Subject: Military Cutoff Road (SR 1409) from just North of US 74
(Eastwood Road) to Market Street. State Project No.
8.2251001, Federal Project No. NHF-1409; TIP U-2734.

Subject: Minutes from Interagency Hydraulic Design Review Meeting on March 28, 2002 for U-2734 (Military Cutoff Road Widening), New Hanover County

Subject: Draft Minutes from Interagency Permit Review Meeting
on February 20, 2003 for U-2734 in New Hanover County

-L-
 PI Sta. 30+38.034
 $\Delta = 2^\circ 55' 51.5''$ (RT)
 L = 460.397
 T = 230.249
 R = 9,000.000
 SE = NC

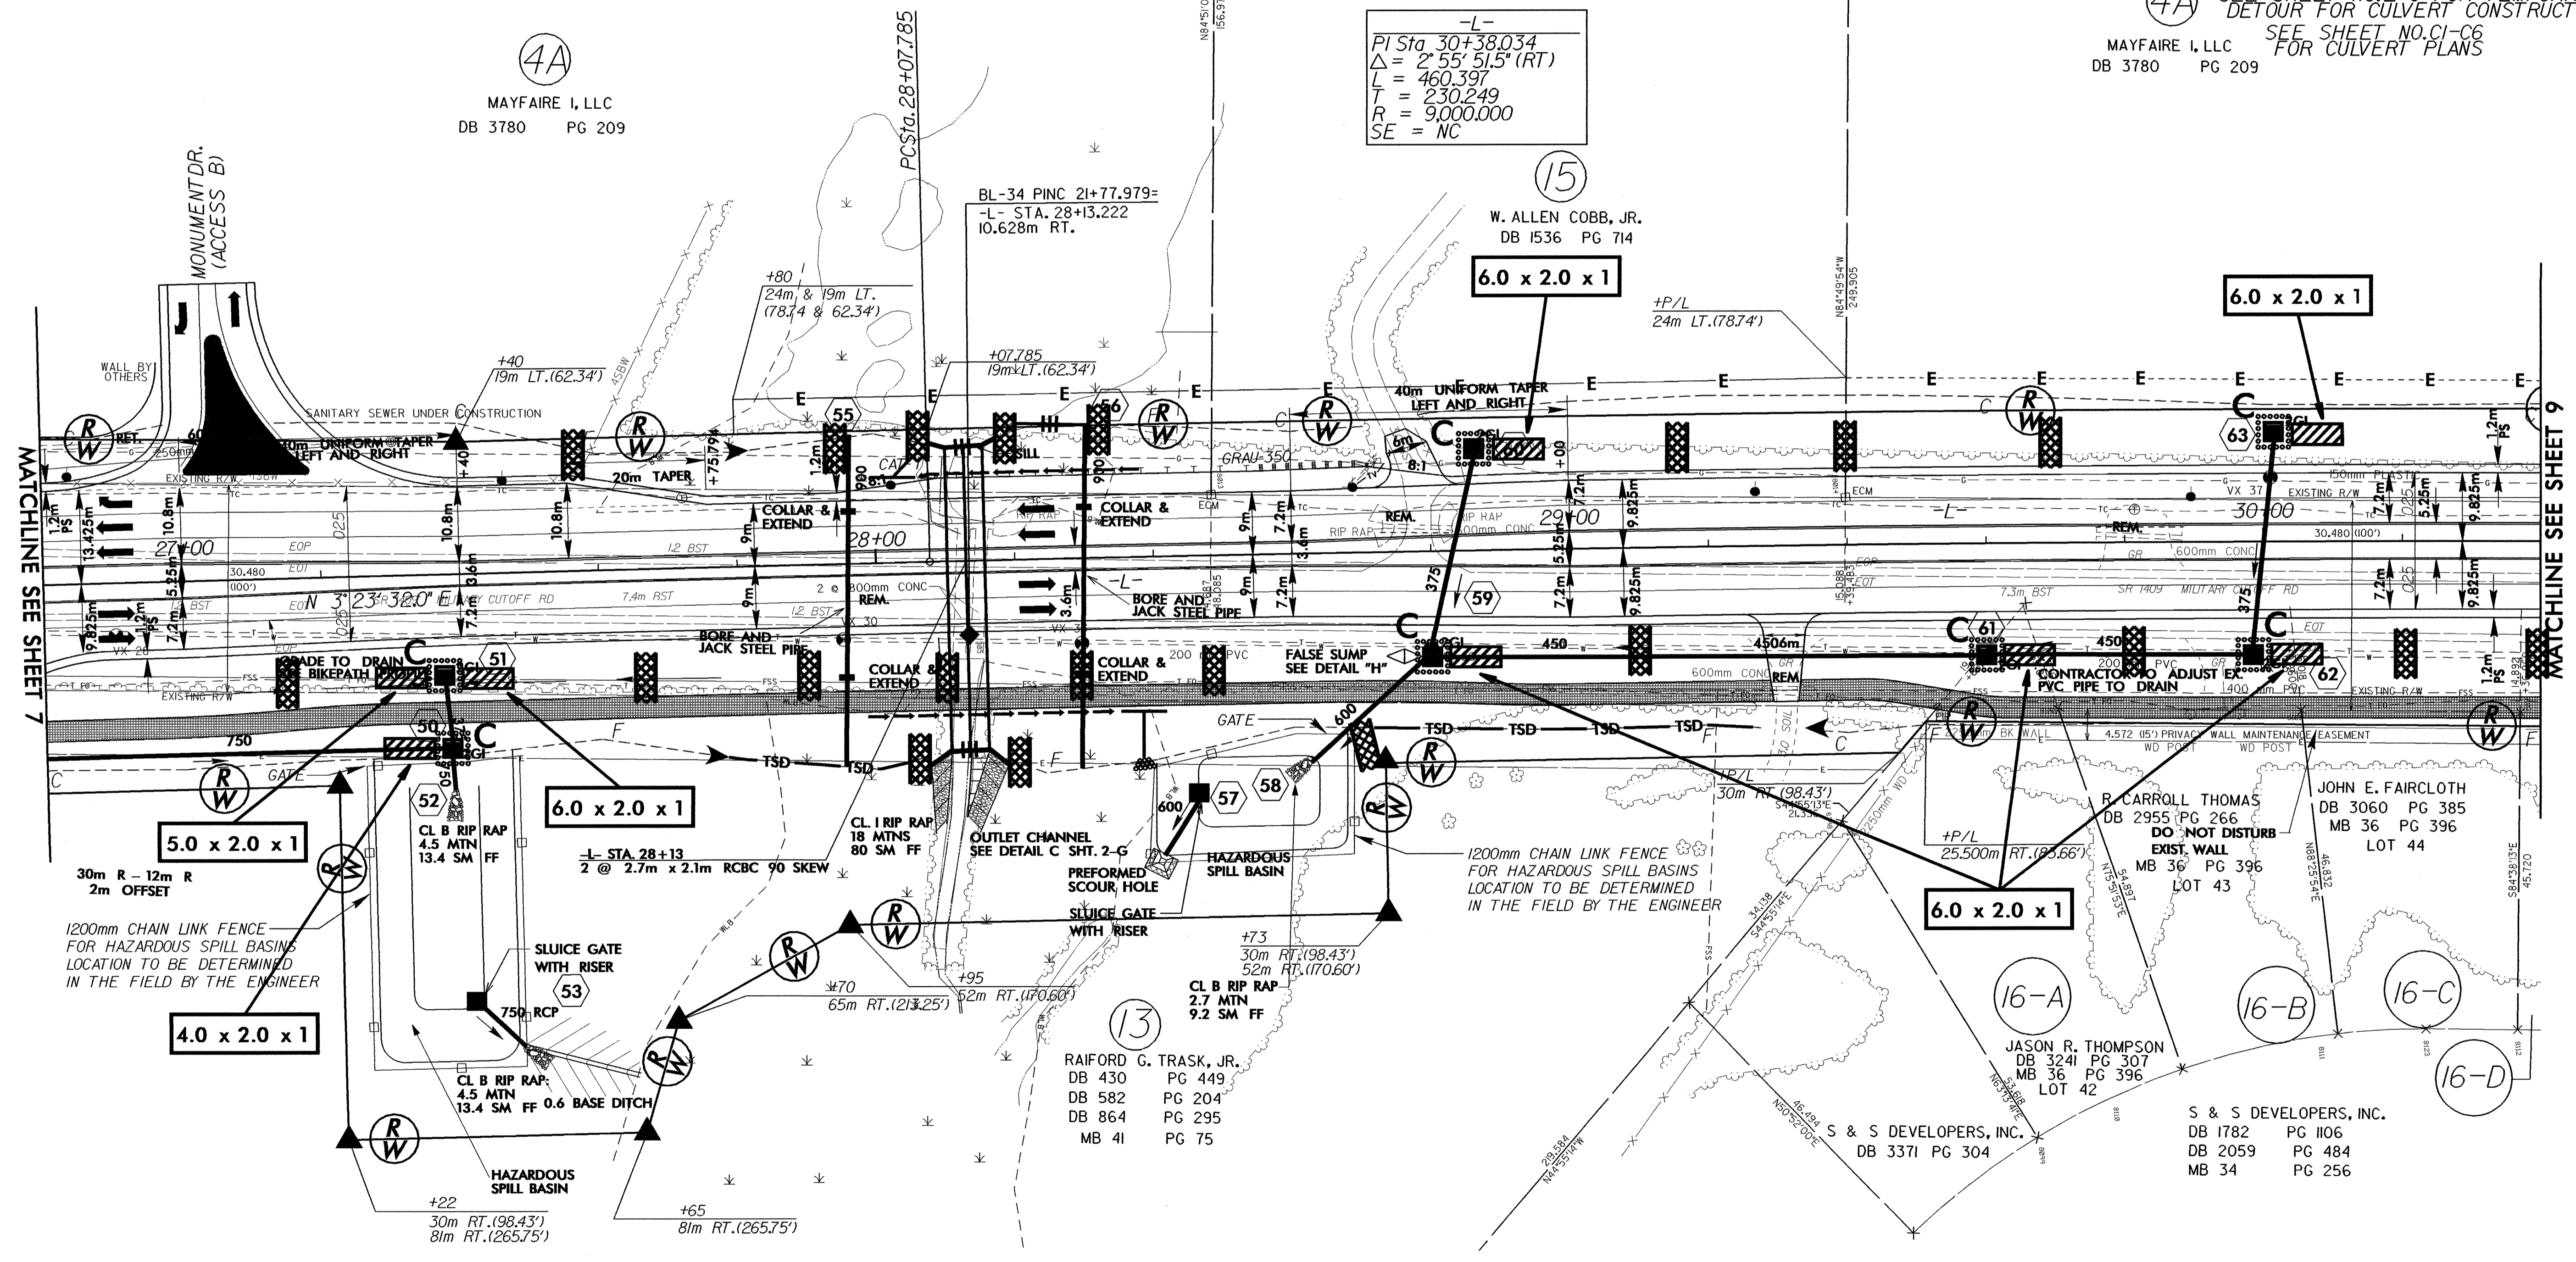
- 1) Wetland and Stream Impacts at Howe Creek: The wetland limits at Howe Creek need be reinvestigated. Additional delineation may be required to determine which side is more suitable for hazardous spill basins (East or West side of Military Cutoff Road). Lindsey Riddick will check delineation. It was also questioned whether stormwater could even outlet in the wetlands or within 575' on each side of Howe Creek since it is considered an Outstanding Resource Water and falls under CAMA jurisdiction. Cathy Brittingham investigated and informed that, since no CAMA permit is required for this section of Howe Creek (non-navigatable) and it is not an AEC, stormwater can outlet within the 575' buffer and in the wetlands. However, velocities must be non-erosive.

- 2) Hazardous Spill Basins at Howe Creek: Dave Timpy emphasized the importance of constructing the basins on the side which will result in the least impact to the wetlands. John Hennessey wanted to know what treatment is provided since the hazardous spill basin is not a treatment facility. He was informed that treatment is acquired as stormwater traverses to the basins through grassed swales and also through storage provided by raised grated inlets (6" at each inlet) in the swales. John also emphasized that outlet velocities into the Howe Creek basin need to be non-erosive and flow spreaders should be considered. Also the basins, as designed, need to be relocated out of the wetlands.

It was determined to keep the proposed hazardous spill basins on the east side of Military Cutoff based on the following:

See above responses.

NOTE: SEE SHEETS NO. 17 & 18 FOR -L- PROFILE
 SEE SHEET NO. 22 FOR -BIKE- PROFILE
 SEE SHEET NO. 2-H FOR NATURAL STREAM
 DESIGN DETAILS & PROFILE
 SEE DETAIL SHEET NO. 2-J FOR -BIKEPATH-
 ALIGNMENT

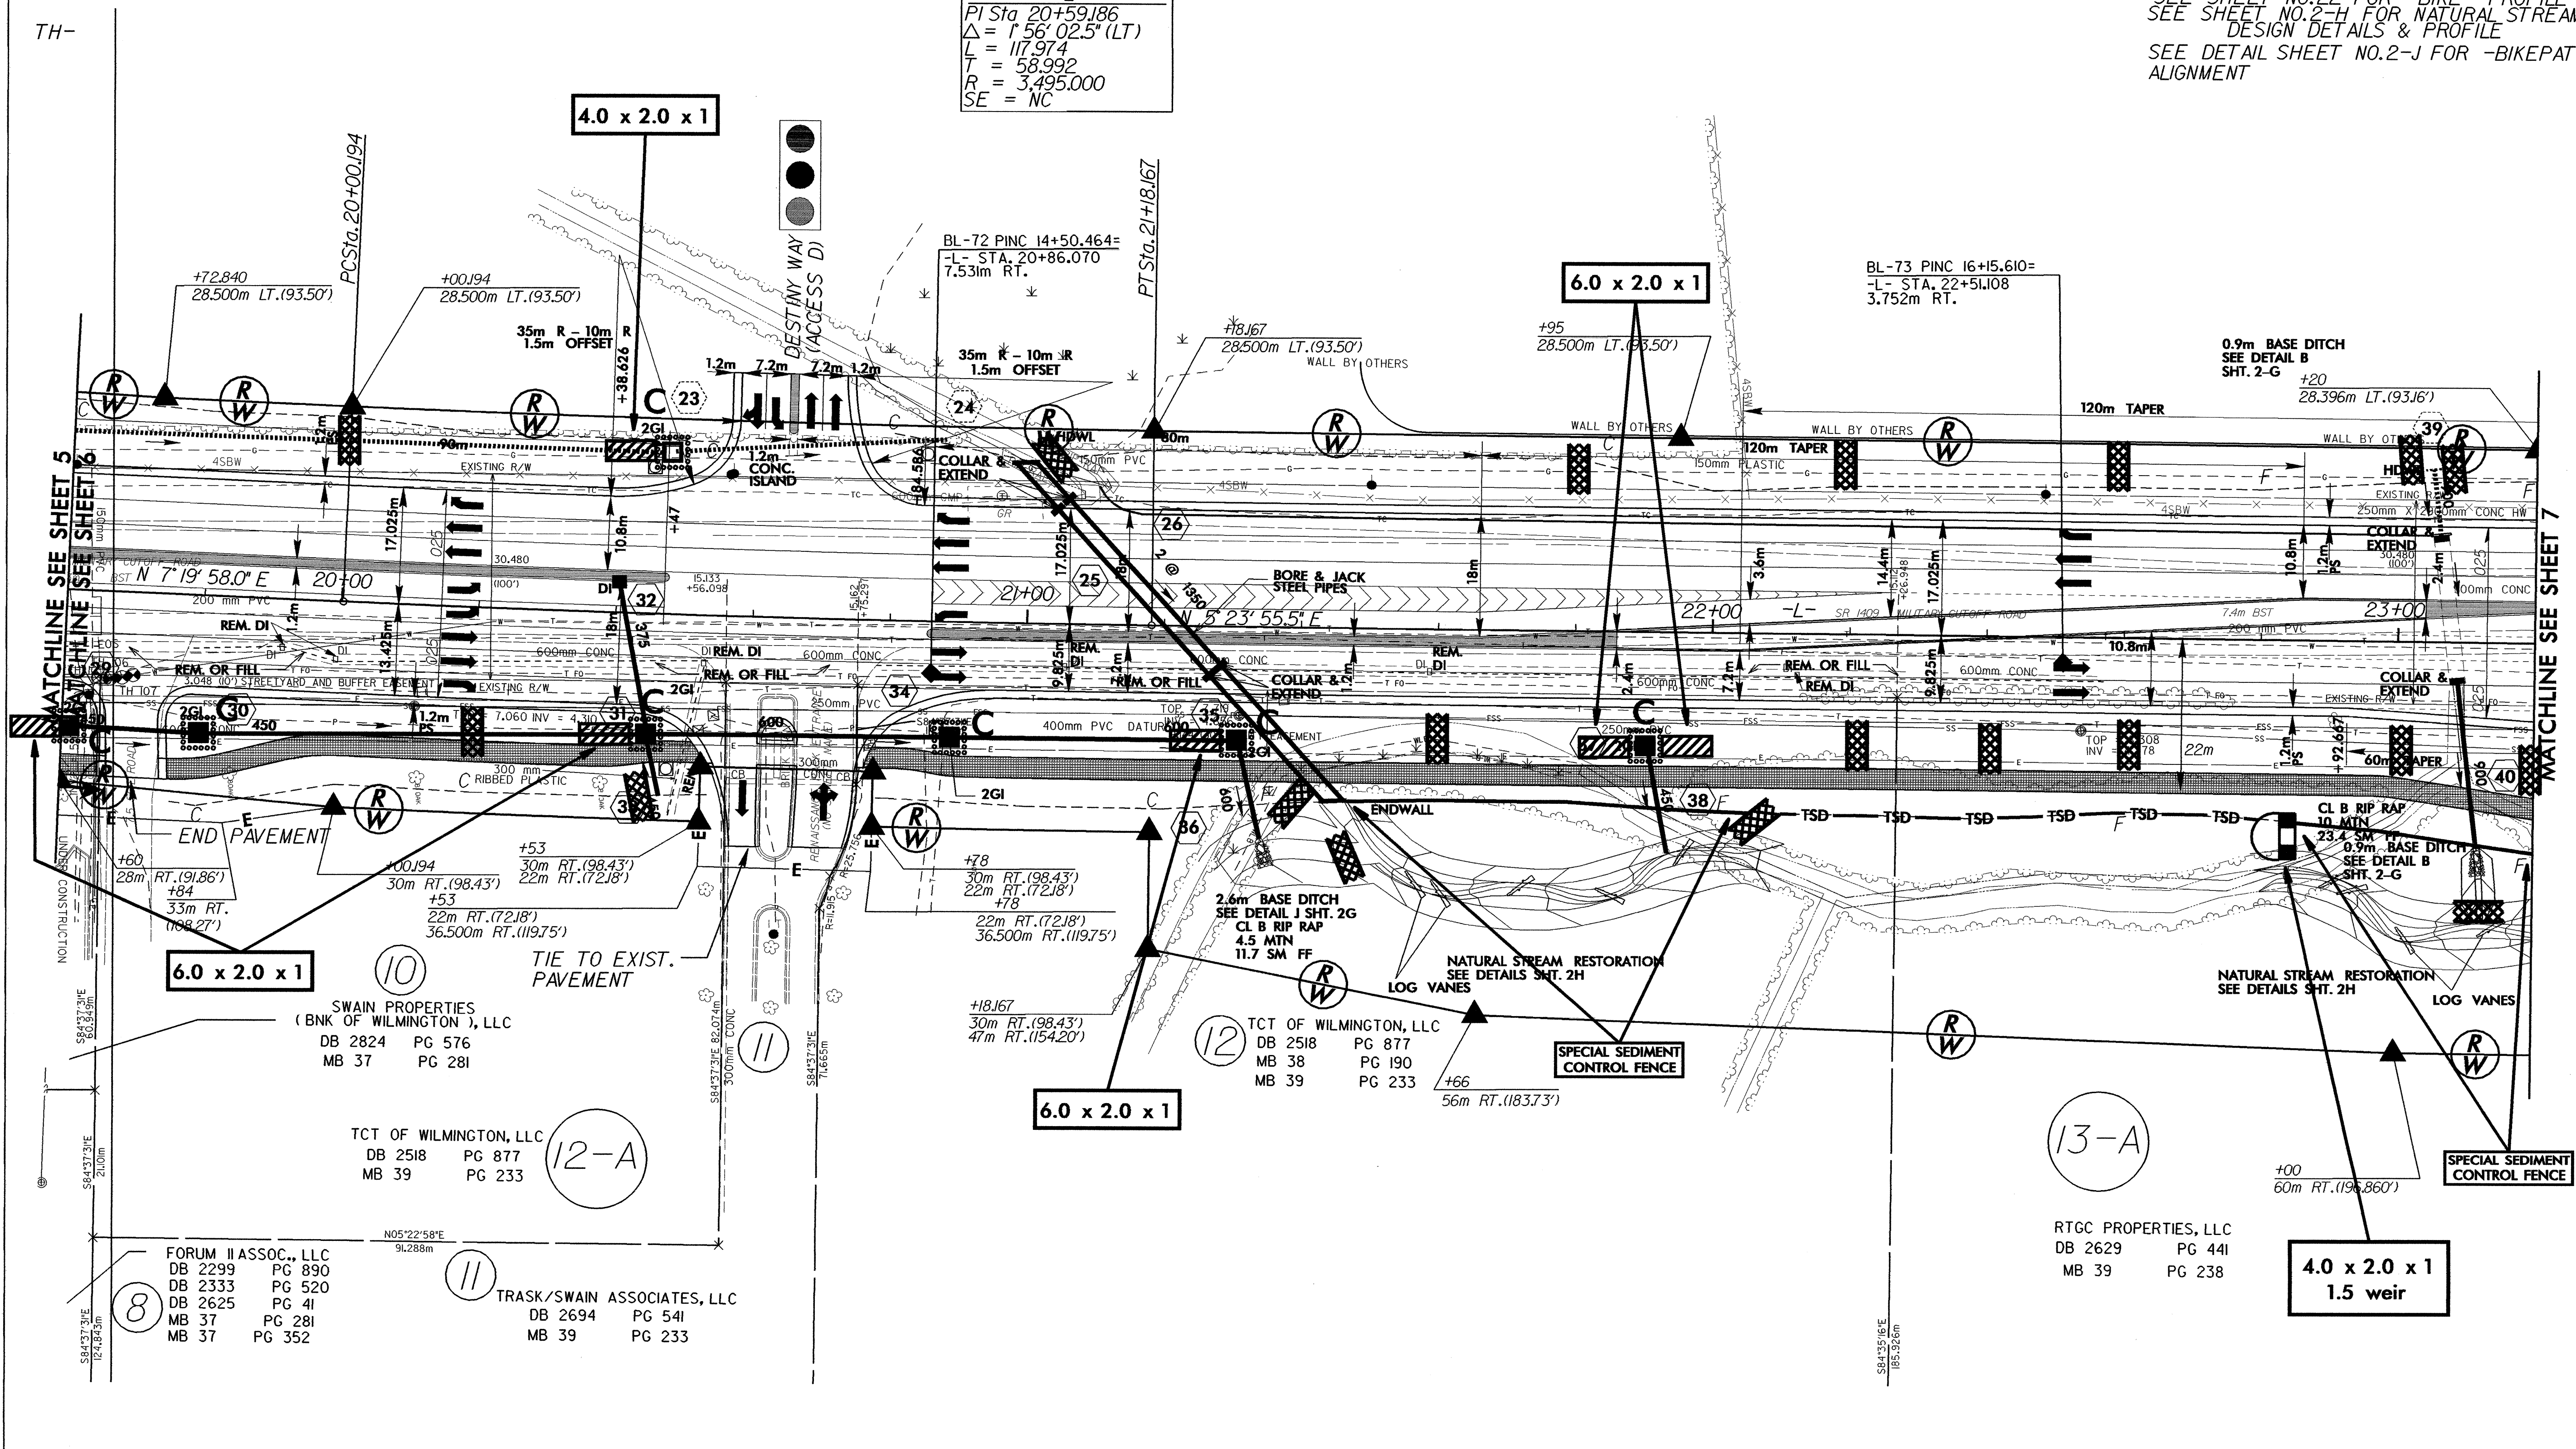
- 4) Proposed Pipe Culverts at Sta 21+43 –L- with Natural Stream Design: Bill Stephens and Marshall Clawson informed that the existing stream flowing towards Military Cutoff Road Sta 21+00 –L- (Lt) does not traverse under the road to Sta 21+90 –L- (Rt) as it seemingly should do based on the natural alignment of the stream. However, pipes are proposed to do so along with natural stream design (nsd) for those portions of stream impacted. All agency representatives wanted information detailing the nsd including stream morphology, typicals, and alignment.

It was discussed that Dave Timpy requested, after reviewing in the field with Galen, to revise the stream relocation by retaining the existing remnant stream and providing relocation in only the areas that are being filled. He also requested providing more stream relocation than is presently being proposed by starting further Southeast. John thought this was a good idea but to investigate improving the remnant stream dimension, since Galen suggested it was entrenched. Also, need to provide existing and proposed stream profile. Galen will update morphological data and review with John at a later time.

NSD info provided in permit.

Stream relocation revised per Dave Timpy's recommendations. See "Natural Stream Design" summary.
